Formal Planning Objection

Re: Planning Application 2026/62/90484/E – Change of Use from dwelling to C2 for 4 children, erection of first floor extension and front porch, internal and external alterations.

Property: 143 Church Lane, Gomersal, BD19 4QN

Proposed First Floor General Arrangement Plan 1:50

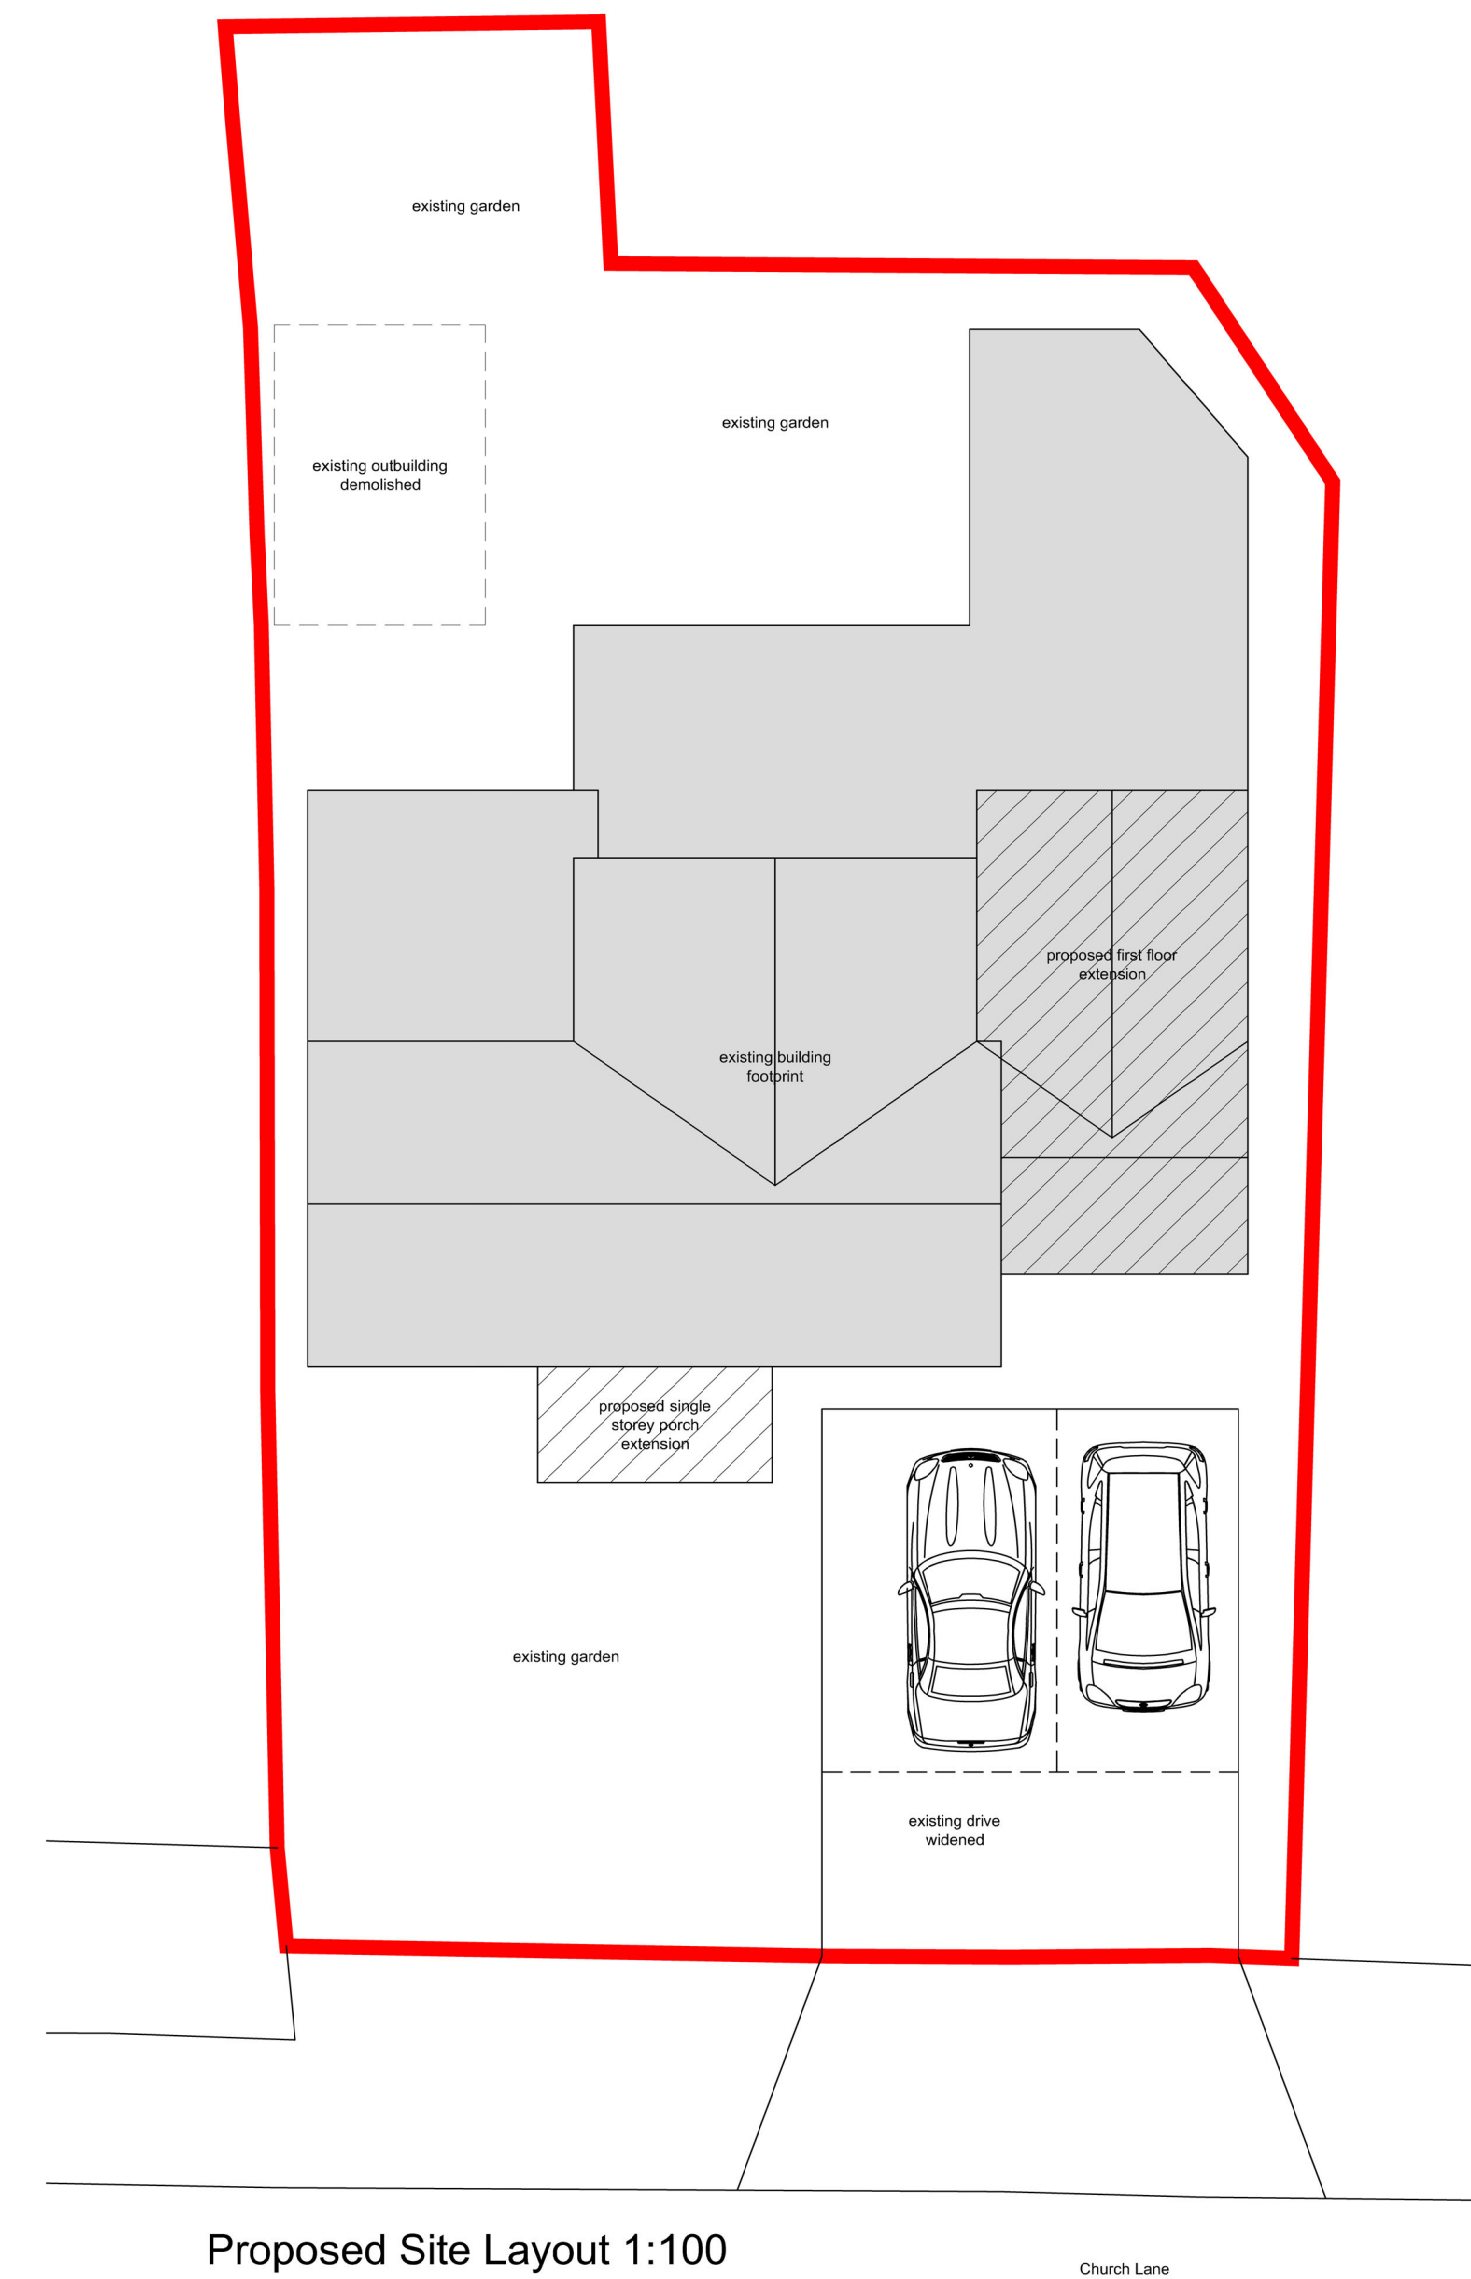
- Upper-floor windows that may function as fire escapes could allow residents to access a flat roof and exit the property.
- Boundary fencing between neighbouring properties is currently low and easily climbable.
- The property is located directly opposite a bus stop with frequent services to Huddersfield and Leeds.
